Application No: A/110/21/PL
Site Address: BMW House Chandlers Garage Ltd Water Lane Angmering BN16 4EH
Description of works: Erection of retirement apartment with 20 No. 1 Bed flats & 13 No.2 Bed flats with communal facilities & car parking, erection of a retail store with car parking & associated highway works. This application affect the character & appearance of the Angmering Conservation area, affects the setting of listed buildings and is in CIL Zone 2 (Zero Rated) as other development.

Thank you for your internet representation made on 28th June 2021 which has been recorded as an objection with the comments as follows:

(2) High Street frontage

Site Sections

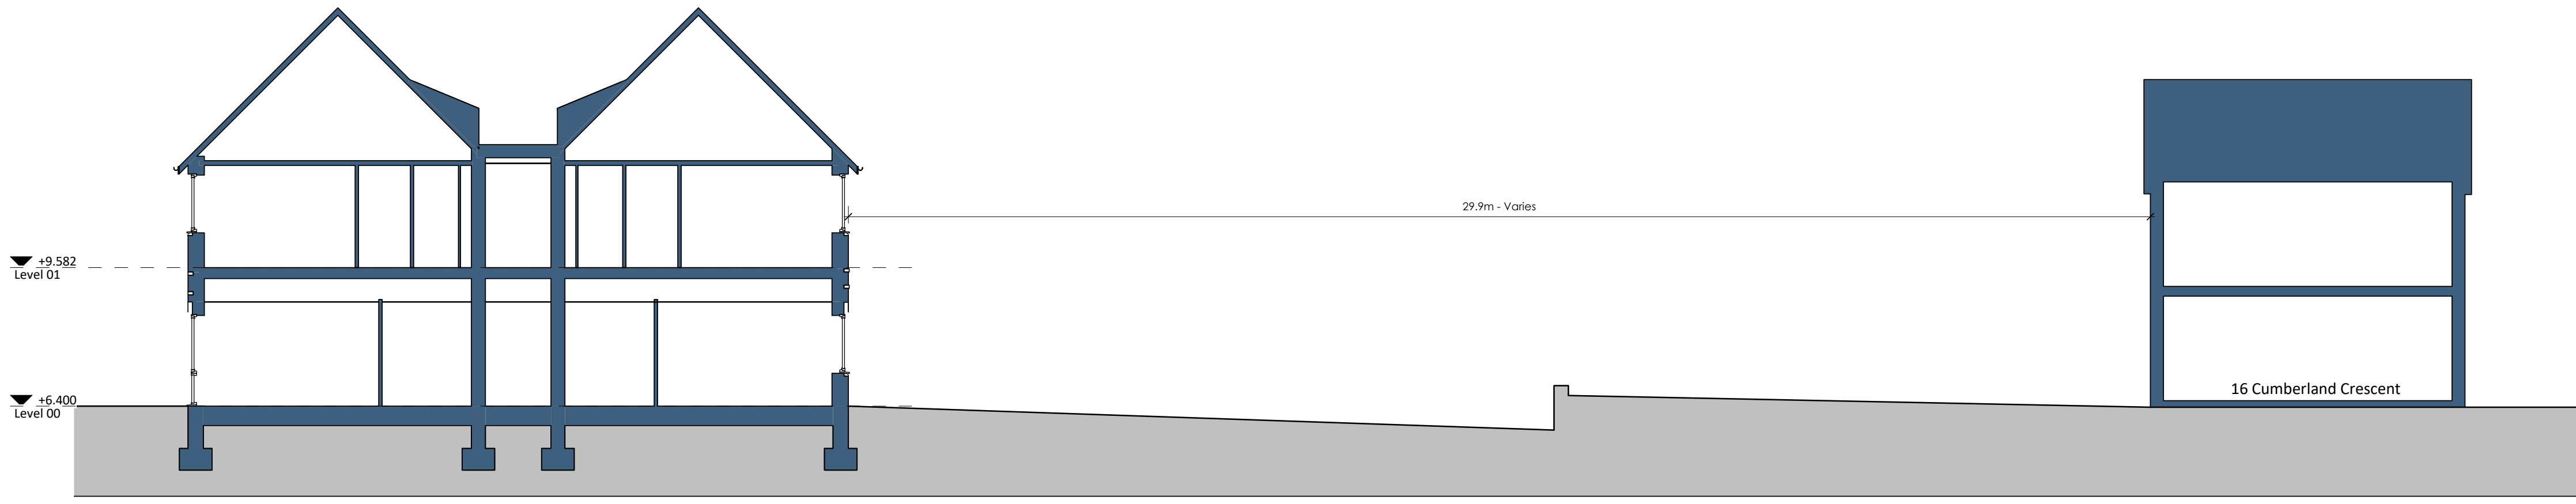
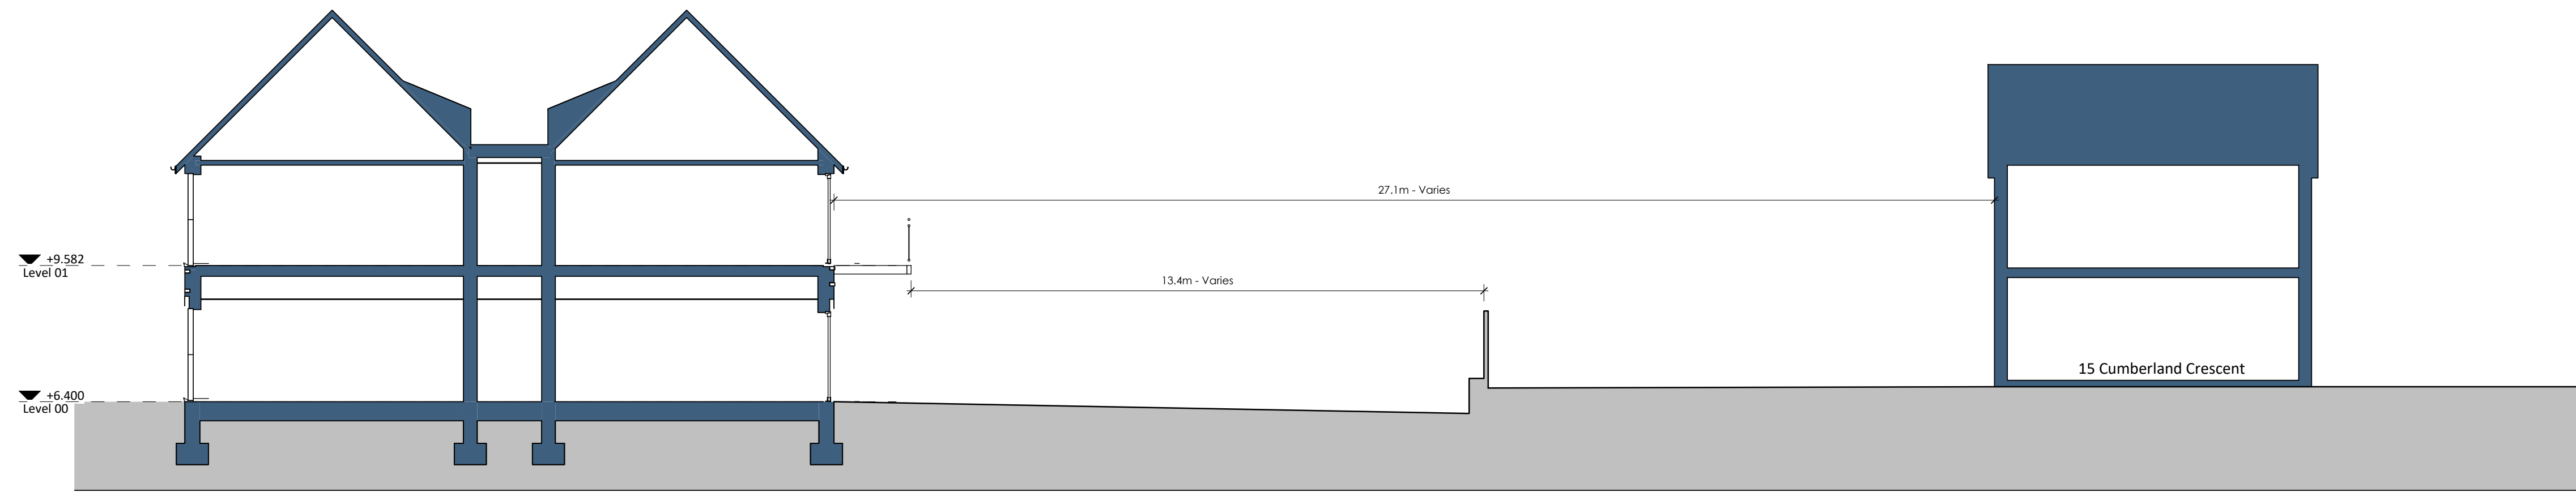
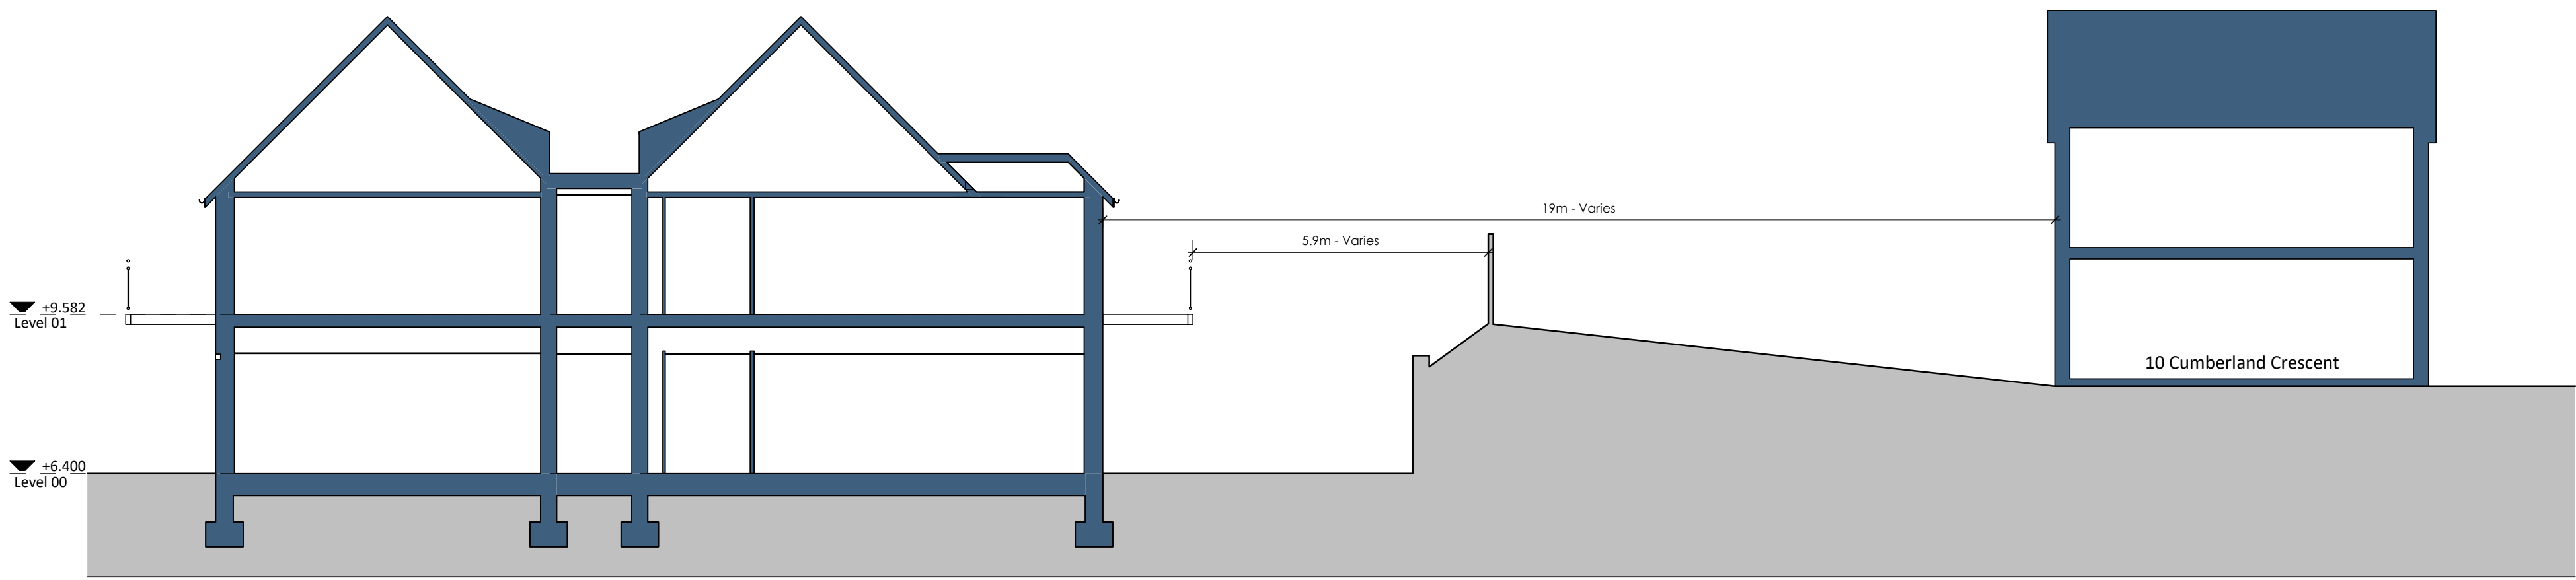
The proposed High Street block will not only sit forward of the listed building but its ridge height is significantly higher due to the depth of the block and the higher land level. This will result in an overbearing effect and will adversely affect the setting of Eachways, made worse by the indifferent design of the block. In addition, the southwest/northeast linking block will crowd the historic building and detract from its setting, particularly as

seen from Water Lane.

Proposed street frontage elevations showing brick and render features.

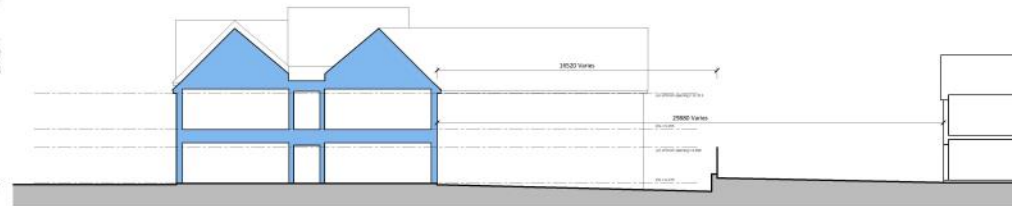
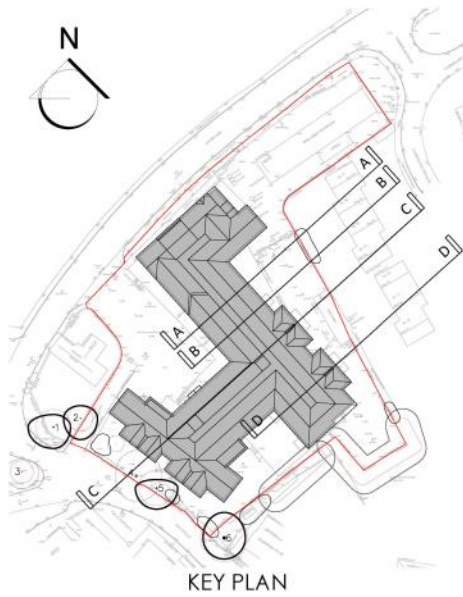
The High Street is characterised by a variety of building age, style and size. However, at its western end in the vicinity of the application site the scale diminishes, with a tighter knit and more intimate streetscape. In this context the proposed terrace is too long and repetitive in its design and borders on monolithic in appearance. The fenestration to the gabled fronts is unresolved and inappropriate.

A shorter terrace of simple but of high quality design and form or a similar design approach as the Water Lane frontage with its variation in facades and materials would be a better solution. The lack of legible door entrances/thresholds and chimney stacks does not help the situation.

The design is considered to be well below the standard which should be required for this sensitive location.
